RE: Engineering - Plan Analysis

1210 Oak Grove Church Road, Angier, NC

Johnson Residence Plan

Project No.:20DDM-0416A-2

Job	Truss	Truss Type	Qty	Ply	Johnson Residence	E14889651
J0520-2323	F01	FLOOR	29	1	Job Reference (optional)

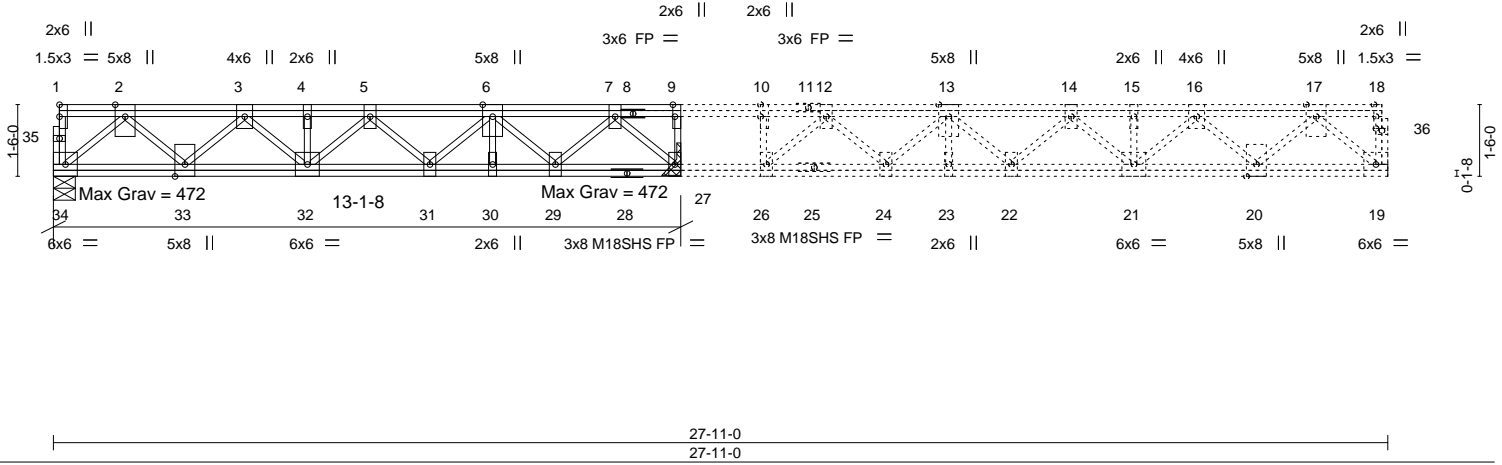
The stairway foundation is outlined on the attached drawing for the new stairway in the garage. The LVL rafter and collar beams can be attached using structural four 8 inch long Timberlok screws in lue of the (2)1/2" diameter through bolts. The stairway opening should be verified for the changes to the floor truss system.
